Ribble Valley Borough Council
Council Offices
Church Walk,
Clitheroe
Lancashire
BB7 2RA

Phone: 0300 123 6780
Email: Kathryn.Walsh@lancashire.gov.uk
Your ref: 3/2025/0139
Our ref: 3/2025/0139/HDC/KW
Date: 01 April 2025

Location: 23 Pendleton Road Wiswell BB7 9DD
Proposal: Proposed change of use of dwelling to holiday let. Building work to extend and renovate the house approved under 3/2024/0574 and 3/2024/0234 has commenced.
Grid Ref: 374637 437491

A2.3.

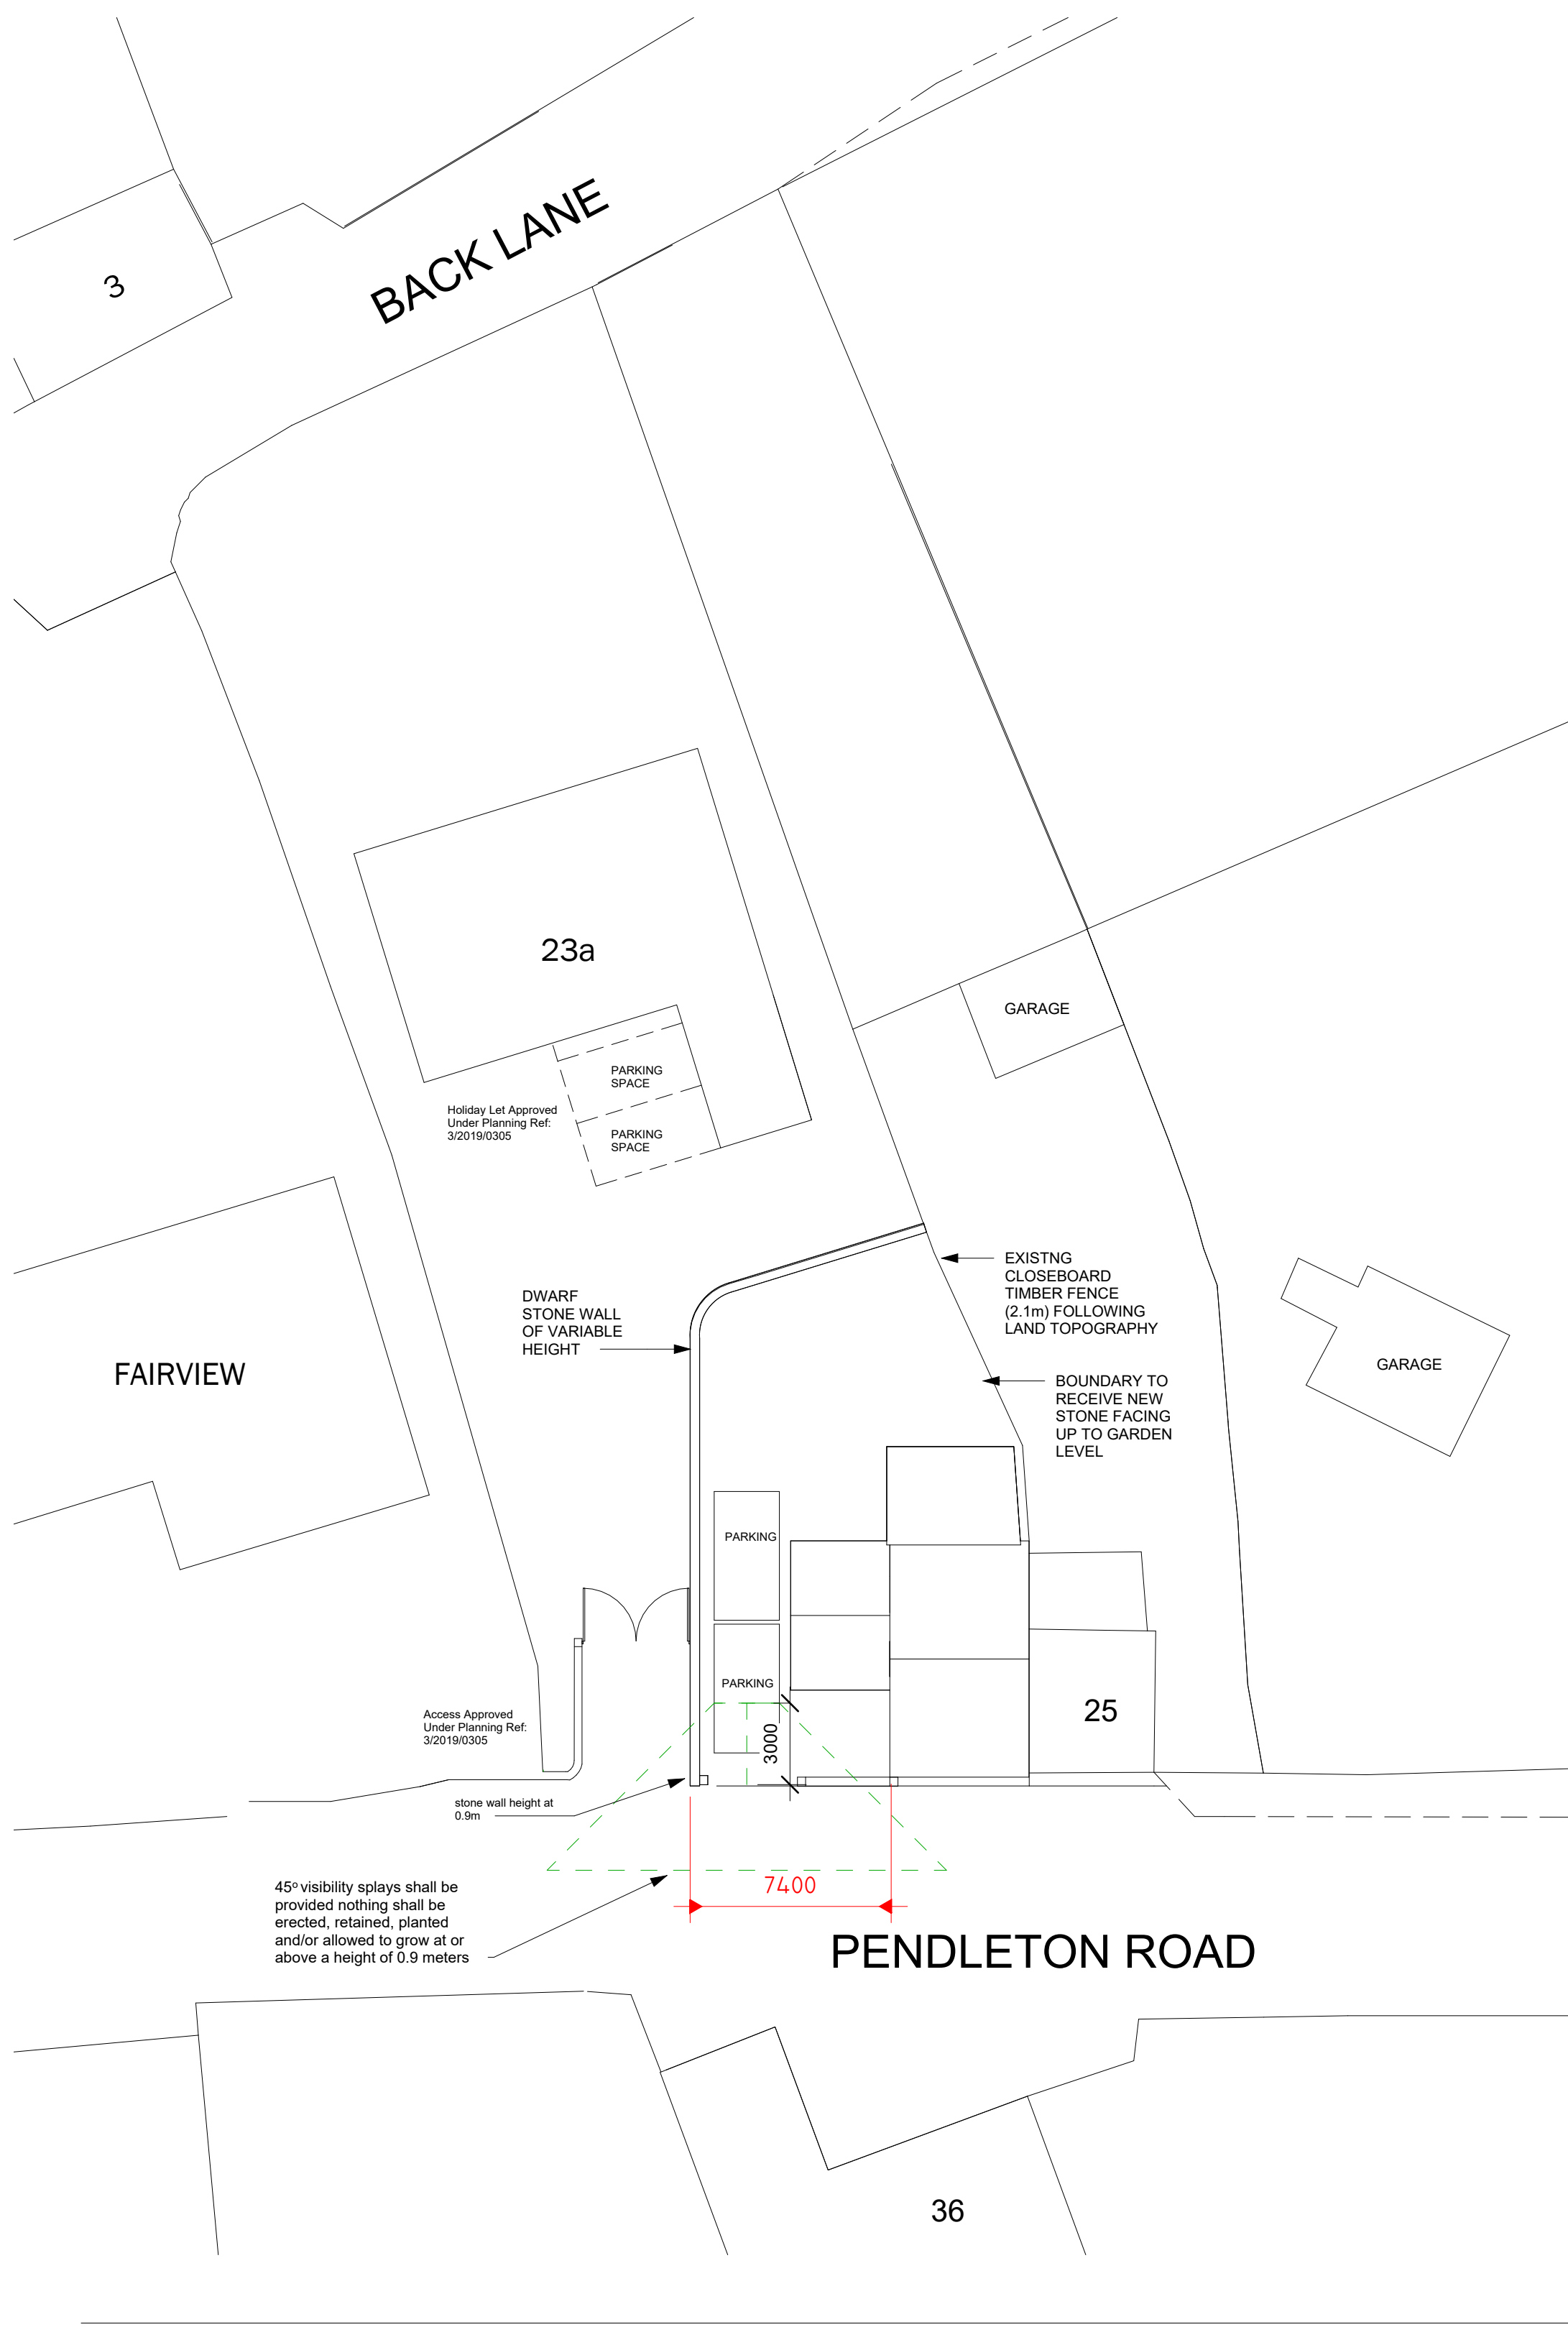
The LHA have reviewed drawing number A2.3. and are aware that the site access will remain as previously agreed under planning applicant 3/2024/0234. Therefore, the LHA have no further comments to make regarding the access.

Drawing number A2.3. also shows that the dwelling complies with the LHAs parking standards as defined in the Joint Lancashire Structure Plan as such the LHA have no objection to the proposal.

If the Planning Authority is minded to approve this application Lancashire County Council Highways requests the following condition be appended to the decision notice:

1. The parking area shall thereafter always remain available for parking of vehicles associated with the dwelling. Driveways/vehicle parking areas accessed from the adopted highway must be properly consolidated and surfaced in bound porous materials, (not loose stone, gravel or grasscrete) and subsequently maintained in good working order at all times thereafter for the lifetime of the development.
